Gravesham Borough Council (GBC)

Lower Thames Crossing DCO

Deadline 7

Comments on (a) DCO Draft version 8 and (b) National Highways Deadline 6 Documents relating to the DCO

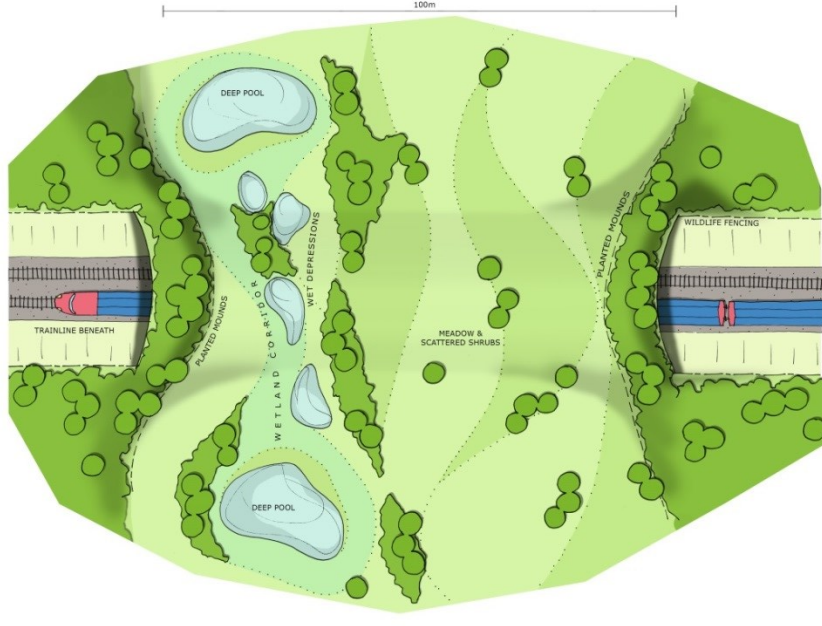
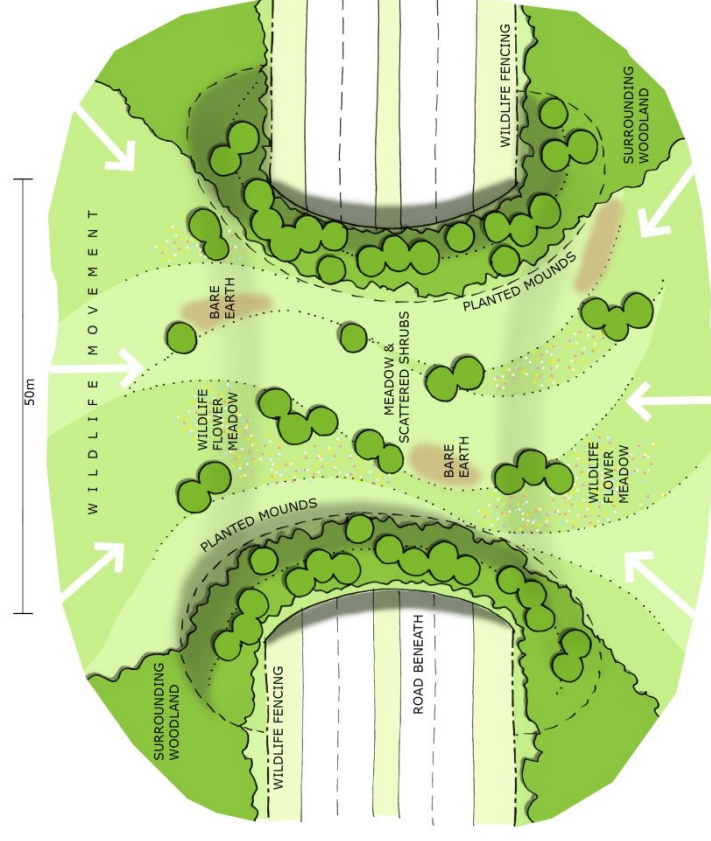
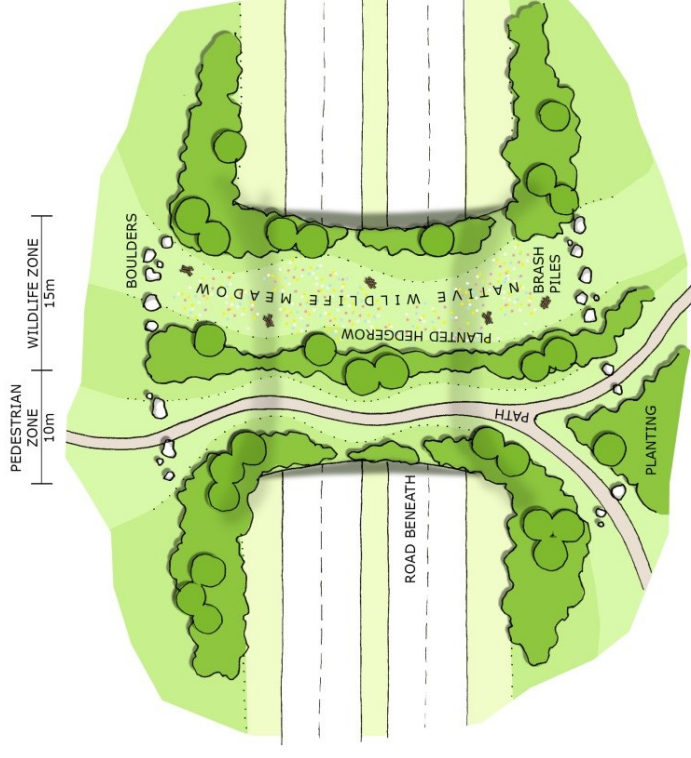
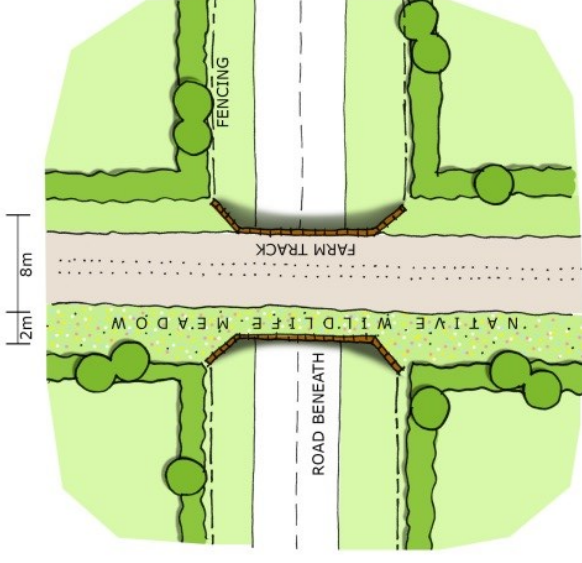
Subject	GBC Comment on REP6-085
<p>Article 10 (construction and maintenance of new, altered or diverted streets and other structures): Green Bridge Design</p> <p>The Applicant does not consider that the boundary between highway and planting and vegetation on the green bridges is necessary and refers to the requirement for as built drawings to be provided to local highway authorities pursuant to the Protective Provisions for Local Highway Authorities.</p>	<p>GBC has considered the protective provisions for highway authorities that were introduced at D5 and is content with the Applicant's explanation.</p>
<p>Article 62 (certified plans, etc.): notice of magistrates' consideration of applications for corrections</p>	<p>See comments on the DCO v.8 above: GBC is satisfied with the amendments to the DCO and considers this matter closed.</p>
<p>Article 65(1)(c) (appeals to the Secretary of State): appeals in relation to stakeholder actions and commitments register</p>	<p>GBC is grateful for the explanation provided which provides clarity on what paragraph (1)(c) is intended to achieve. But GBC still considers that the terminology could be improved. Paragraph (1)(c) refers to refusals of any approval, consent or agreement which the undertaker is required to</p>
